EP/40/12

APPLICATION EP/40/12 115-117 SEA ROAD, EAST PRESTON BN16 1NX

LPA Ref: EP/40/12/
Proposal: 9No. flats with associated parking and amenity space following
demolition of existing buildings
Address: 115-117 Sea Road, East Preston

EP140112.

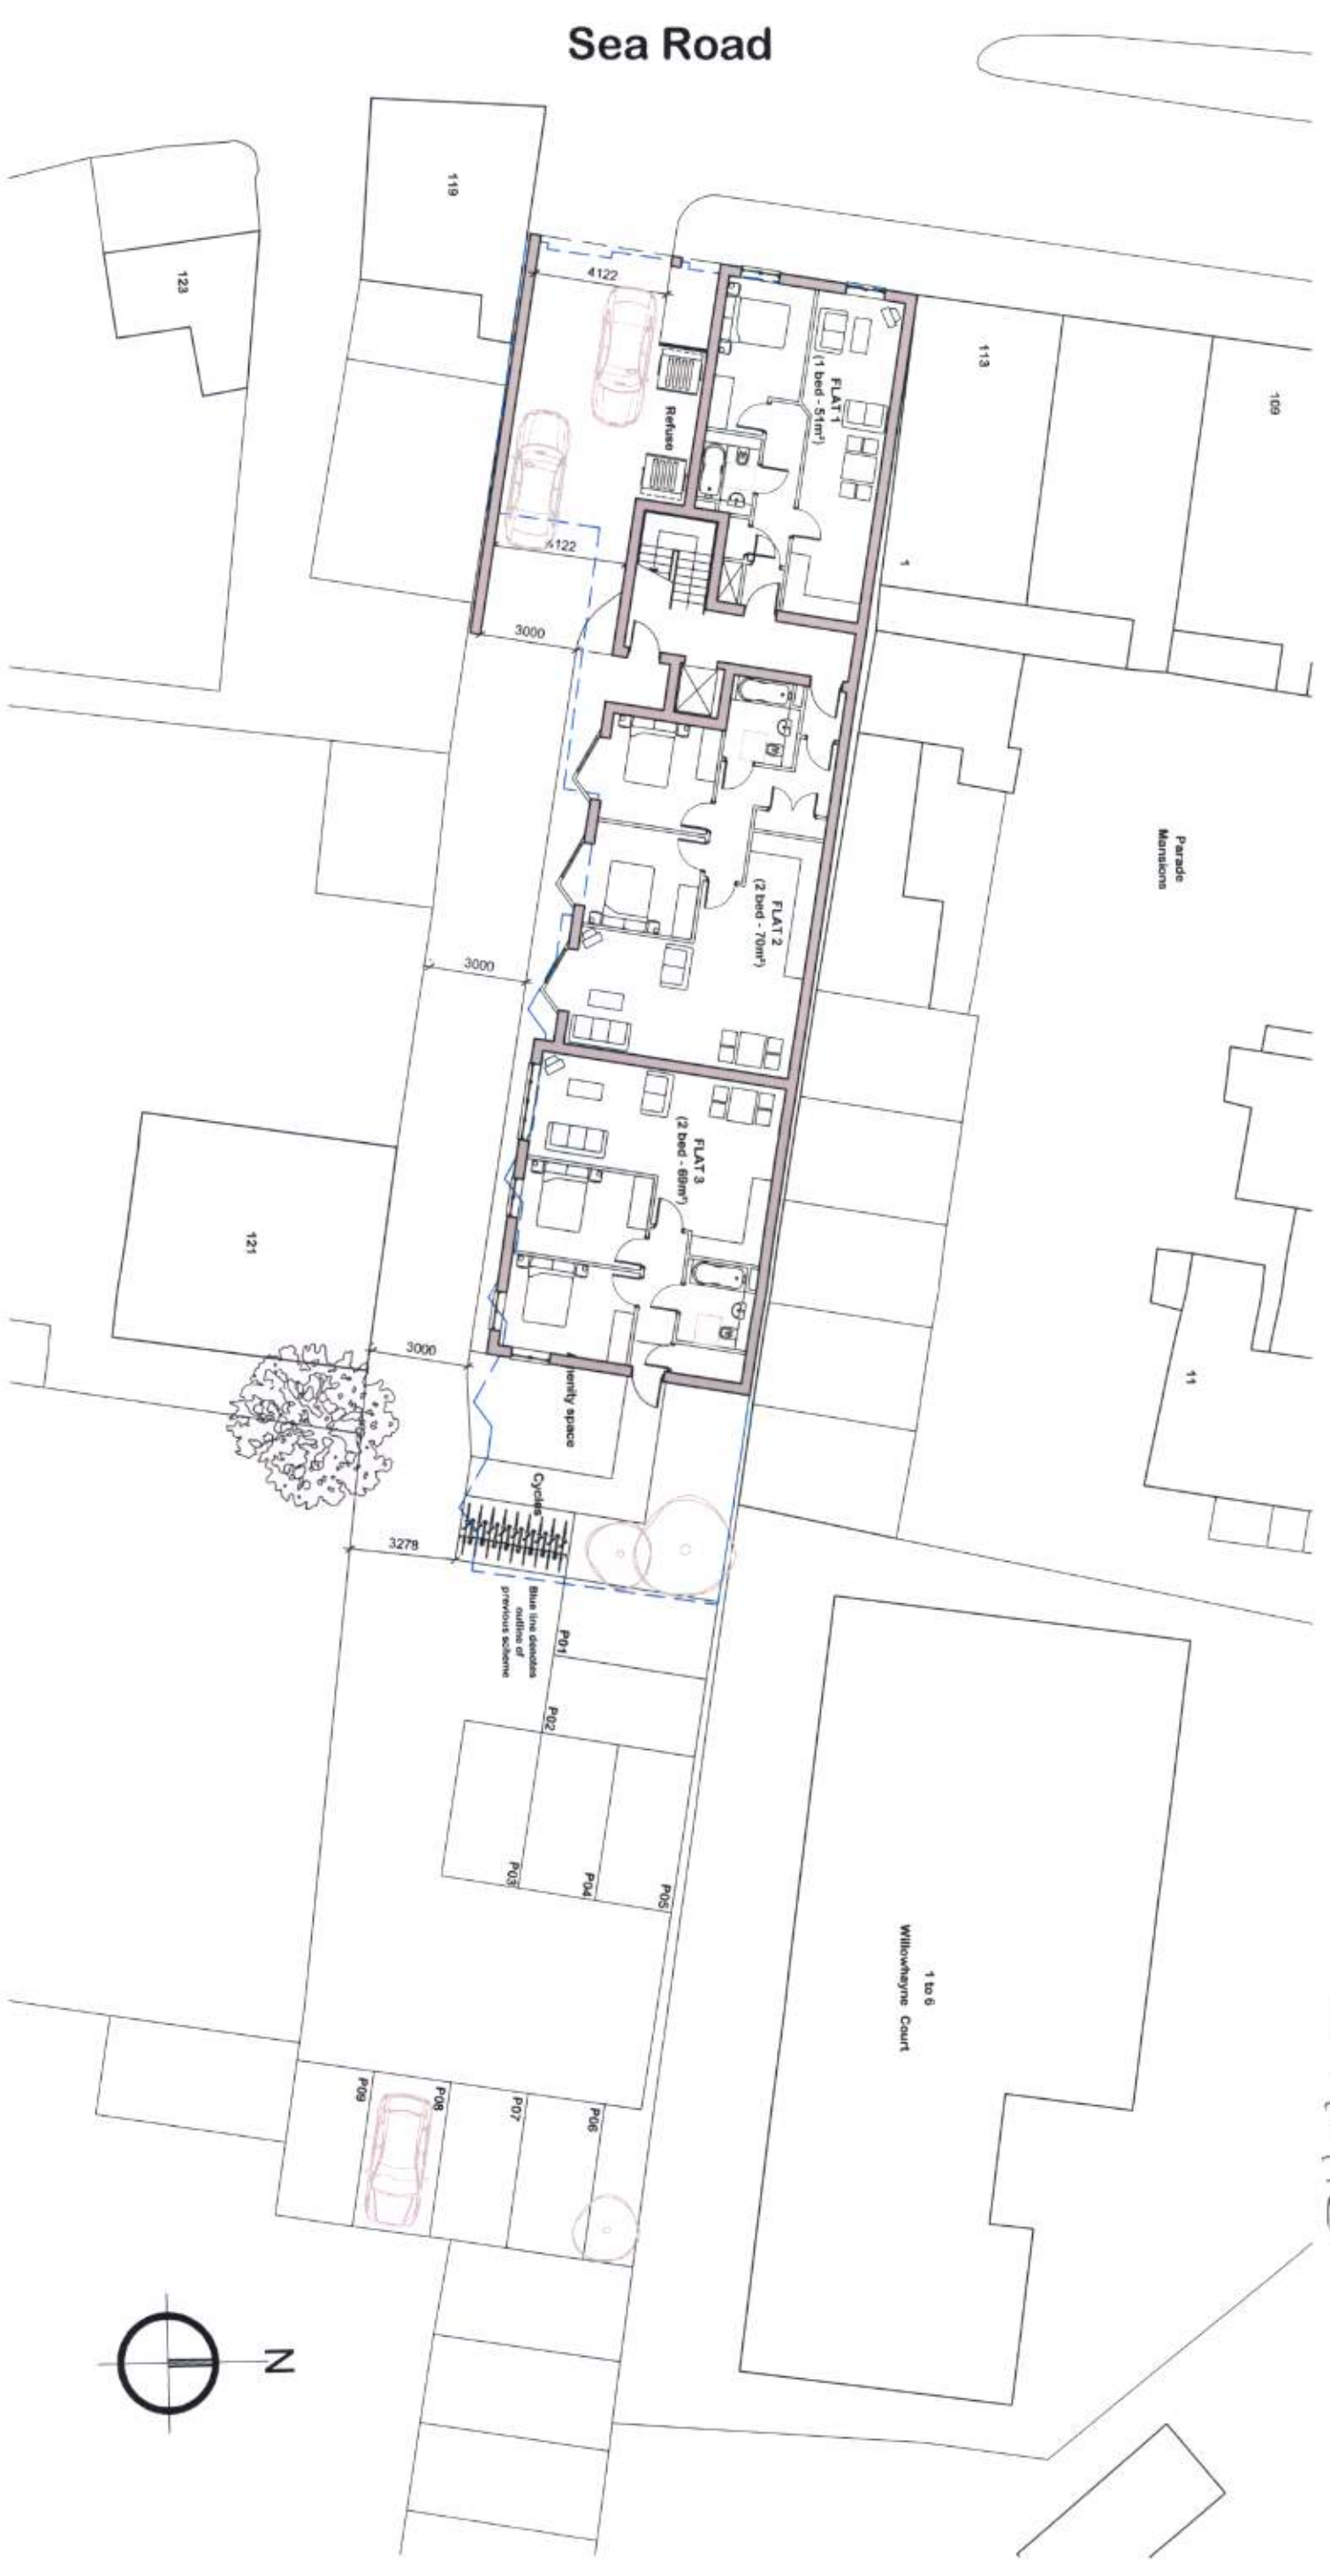
The design and access statement states that "The proposal will introduce biodiversity to the site through the introduction of landscaping" and drawing no 3279/P100 rev C shows amenity space but does not include any detail.

We therefore recommend that details of the landscape proposals are submitted for approval. Approval of these should be sought with a plan showing clearly; species choice, location, density and proposed sizes at planting.

East Elevation

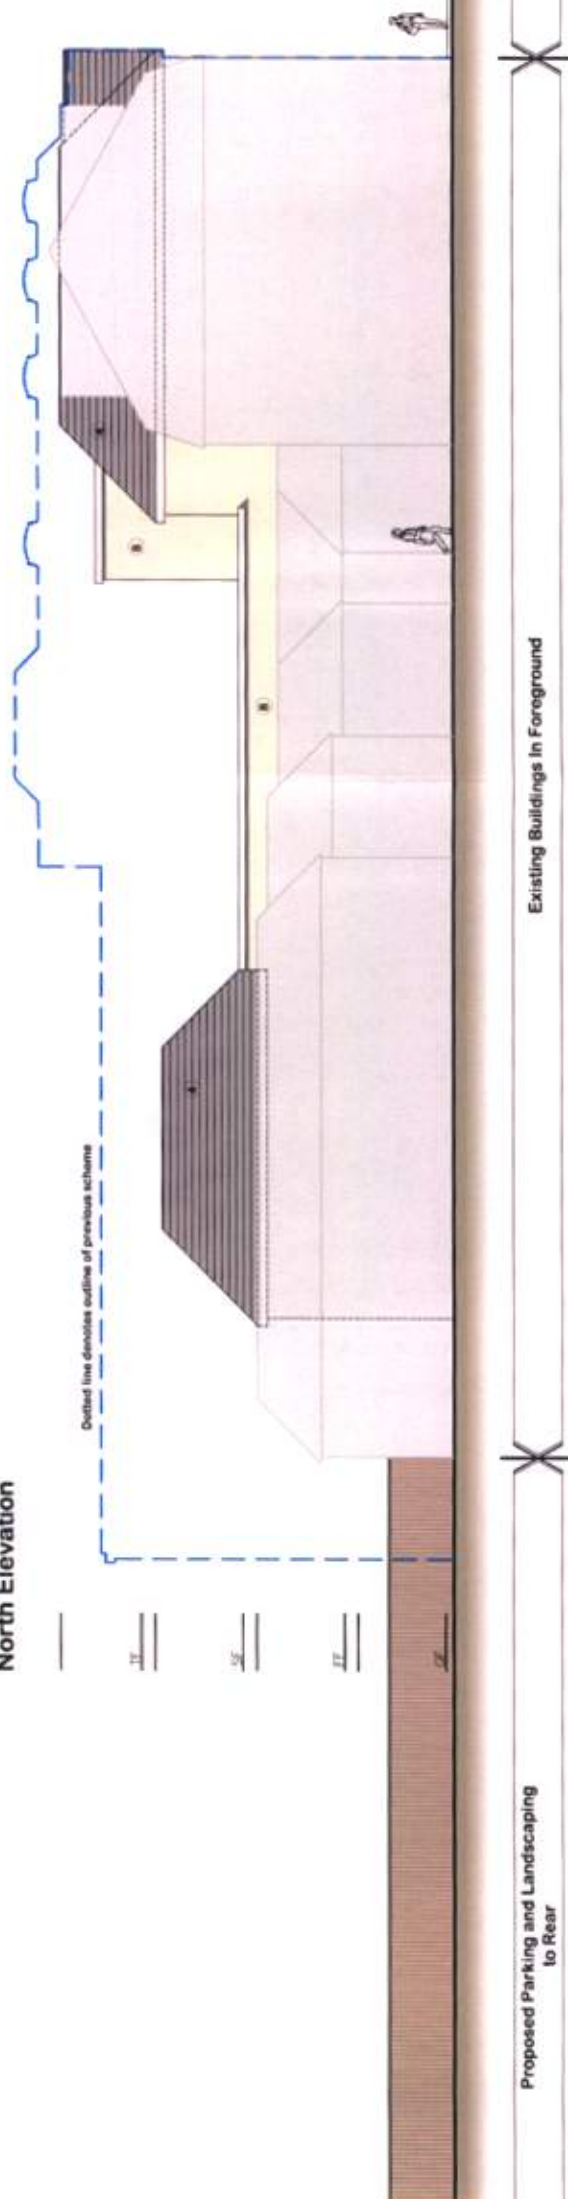
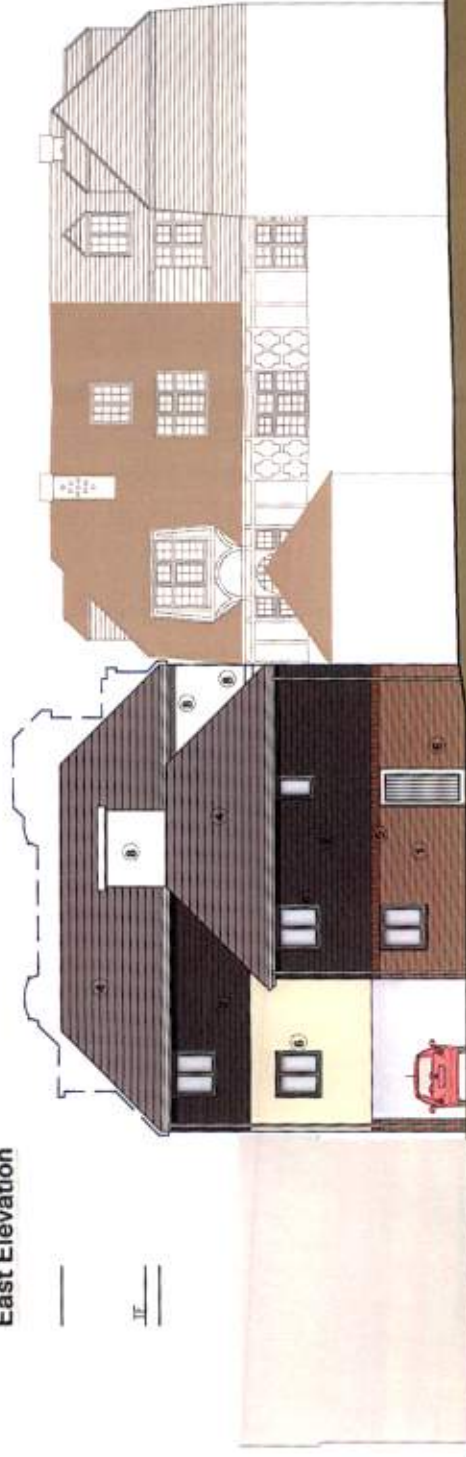
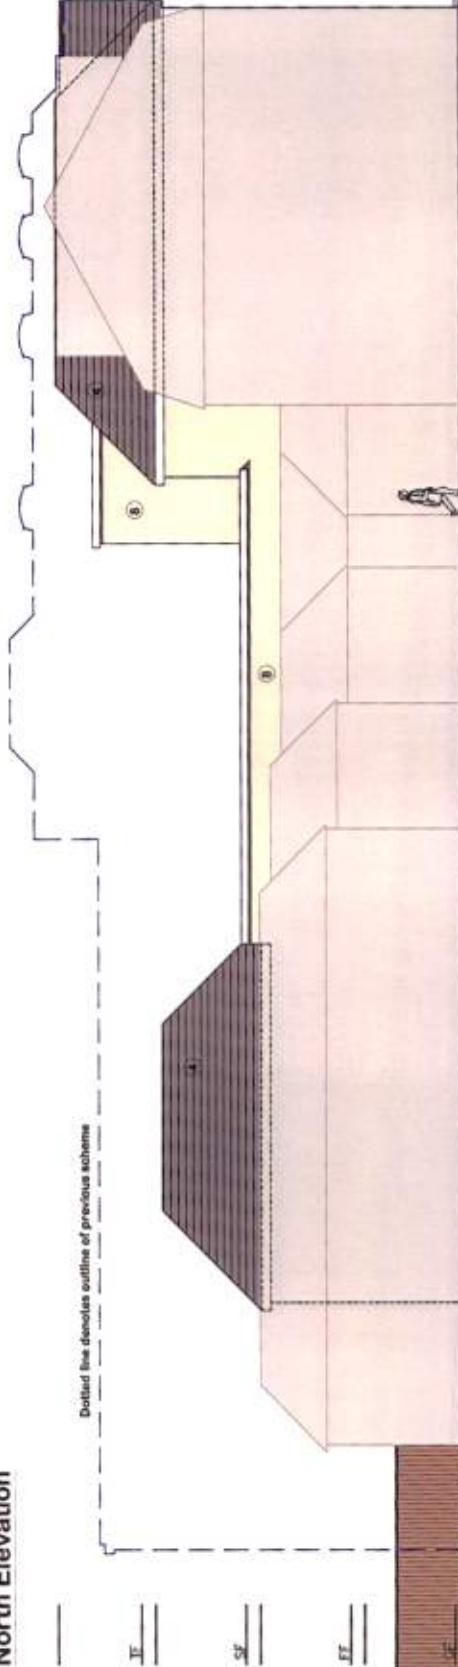
I have updated the front (West) elevation as per our discussions and have also updated the South and East elevations to carry the render around the corner. This is now more in-keeping with the neighbouring buildings.

With regards to design I agree that this needs to be revised as the proposed structure when viewed from Sea Road in context with the Parade Mansions is currently not in-keeping. Parade Mansions are noted for their various use of materials with horizontal detailing and changes of material. Parade Mansions are also listed within the Councils local list of character buildings. The proposed structure varies to this with the introduction of vertical changes of materials. This I believe results in a building which is not in-keeping with the street scene and therefore at present detracts from the locality.

5-9-12
Please sub Dr. No 3279/P200 Rev. C with 3279/P200 Rev. D.
+ Dr. No. 3279/P201 Rev. C with 3279/P201 Rev. D. ✓
